## **Submission relating to Western Harbour Tunnel Environmental Impact Statement**

Western Harbour Tunnel and Warringah Freeway Upgrade

Environmental Impact Statement: project 1045

Application No: SSI 8863

FIGURE 5.7 - YURULBIN POINT (WHT4) AND SYDNEY HARBOUR SOUTH COFFERDAM (WHT5) CONSTRUCTION SUPPORT SITE LAYOUTS

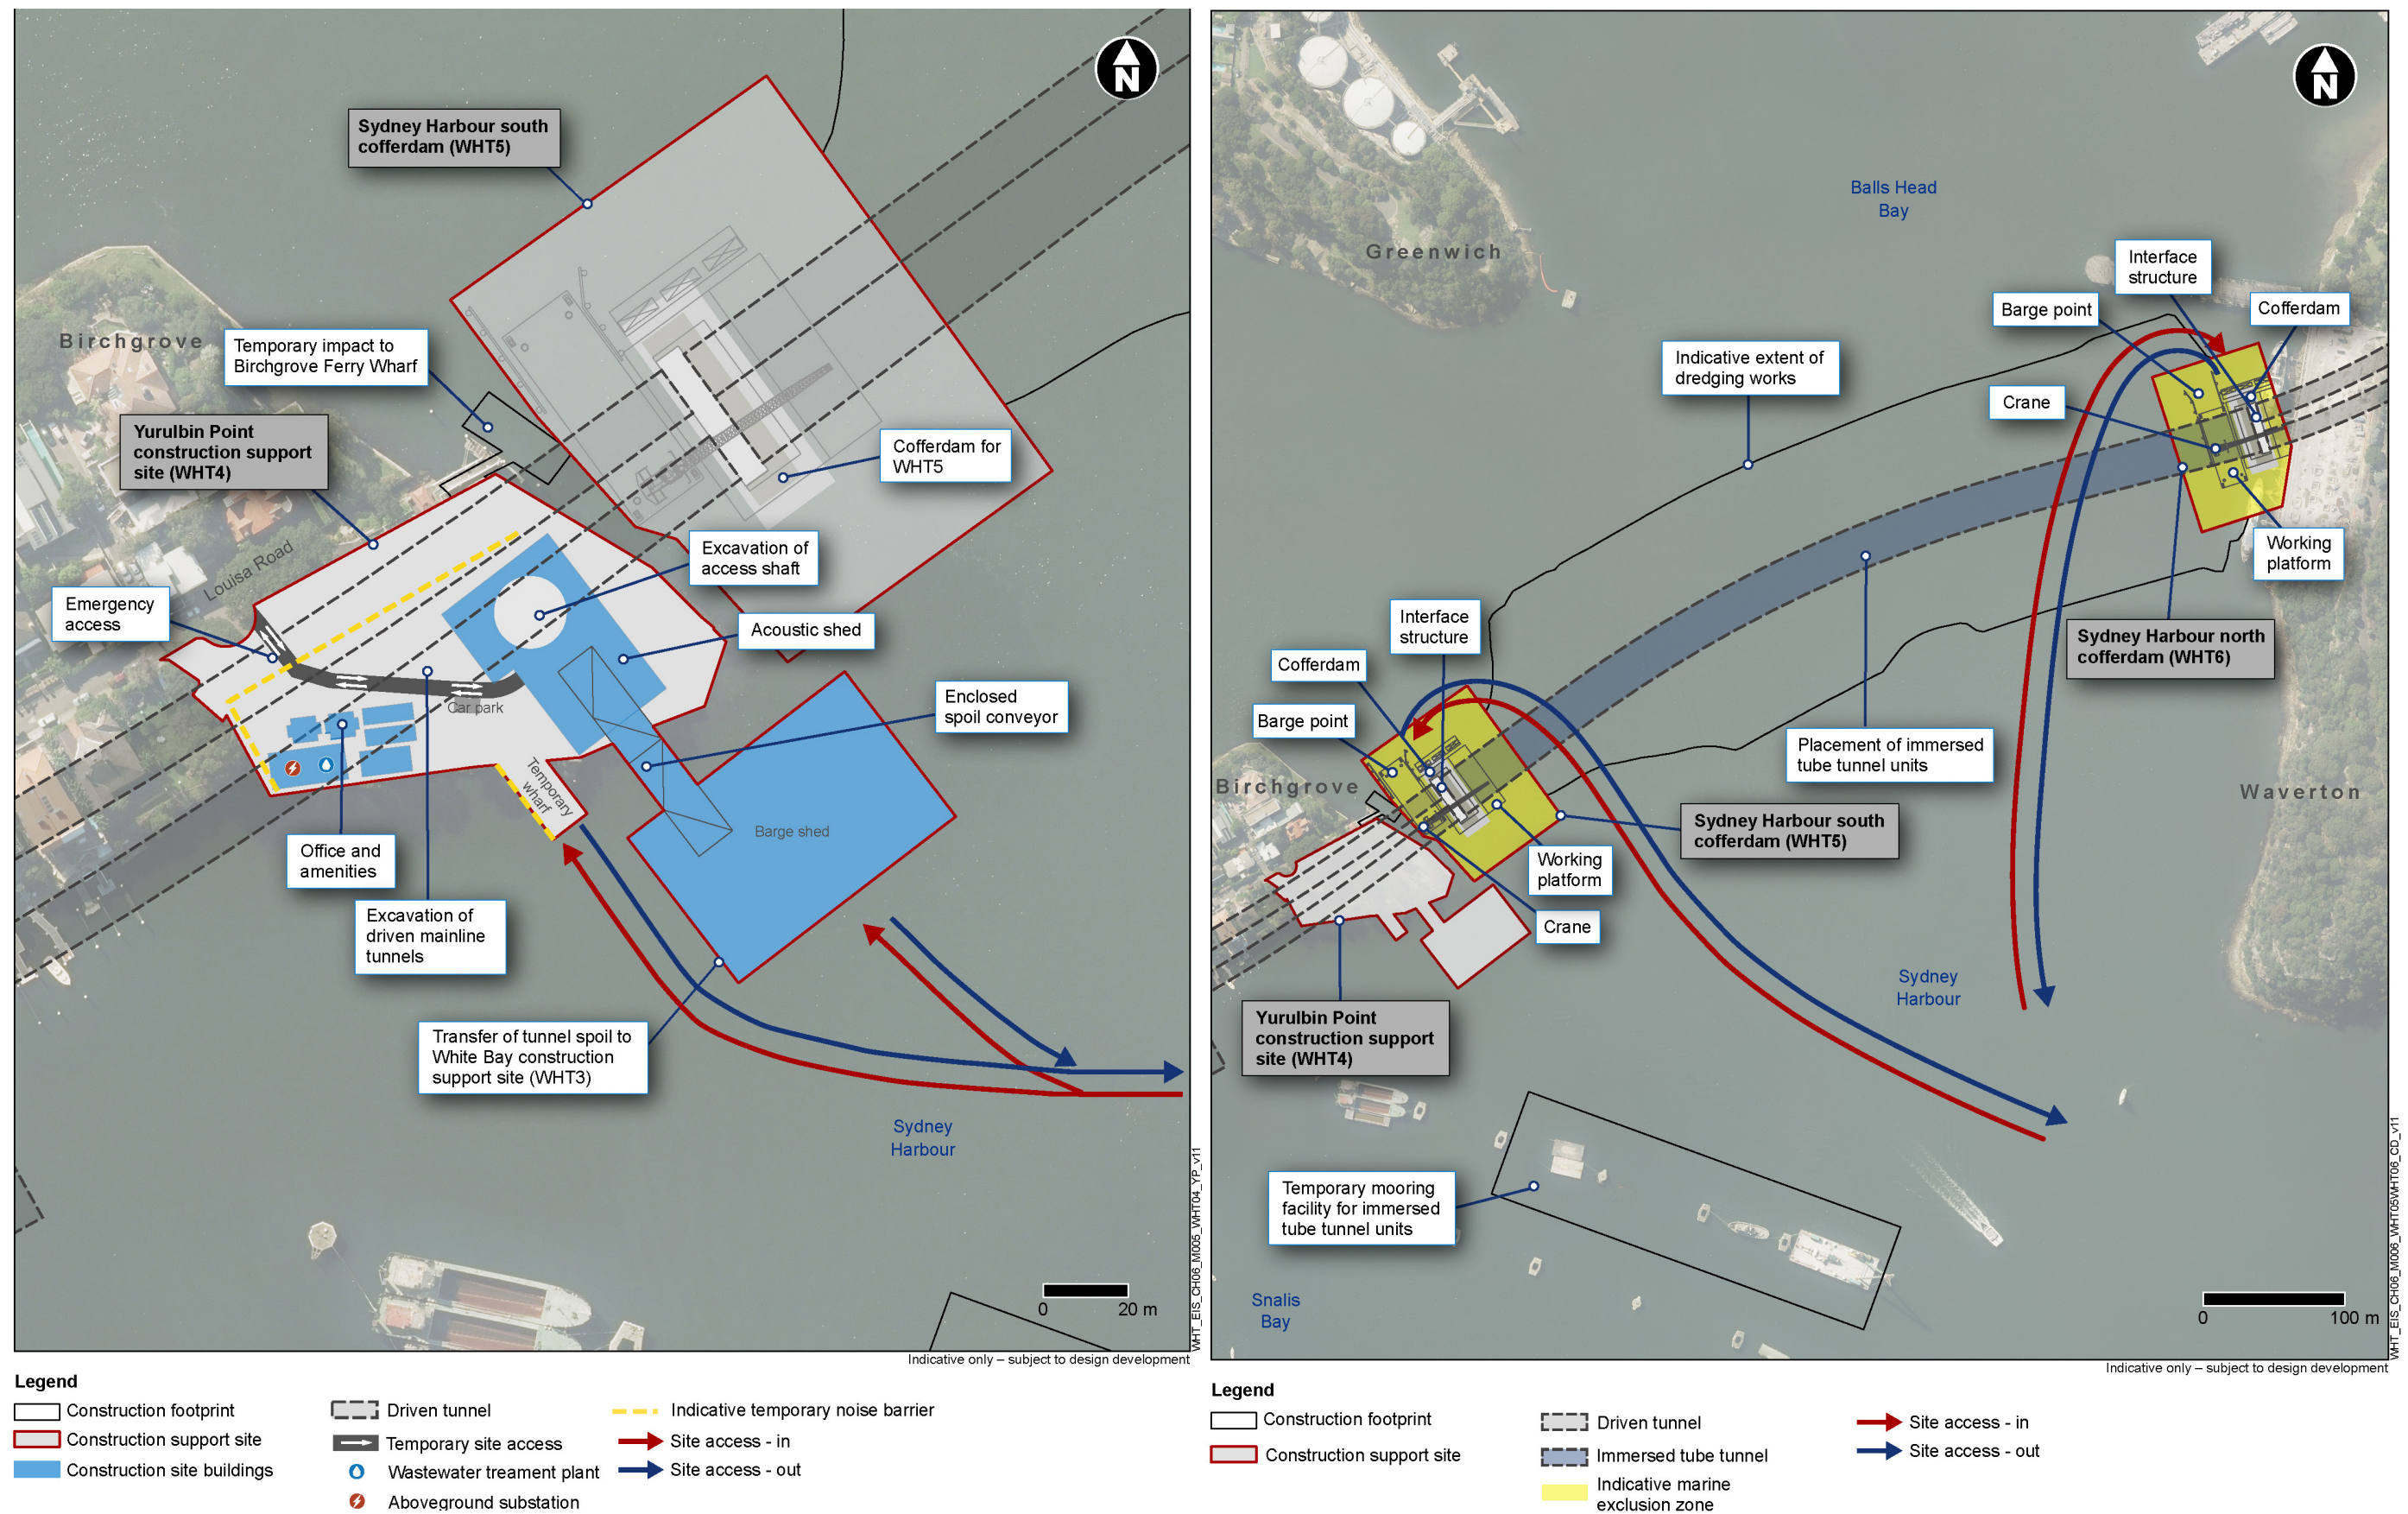
The diagram on page 48 of Your guide to the EIS Western Harbour Tunnel and Warringah Freeway Upgrade indicates temporary noise barrier locations. My home is located about 400m SSW of the Yurulbin Point site. There are no noise barriers between the site and my home (and many other adjacent properties)

The EIS should include requirements that noise barriers completely surround all worksites – particularly noisy work sites likely to work extended hours.
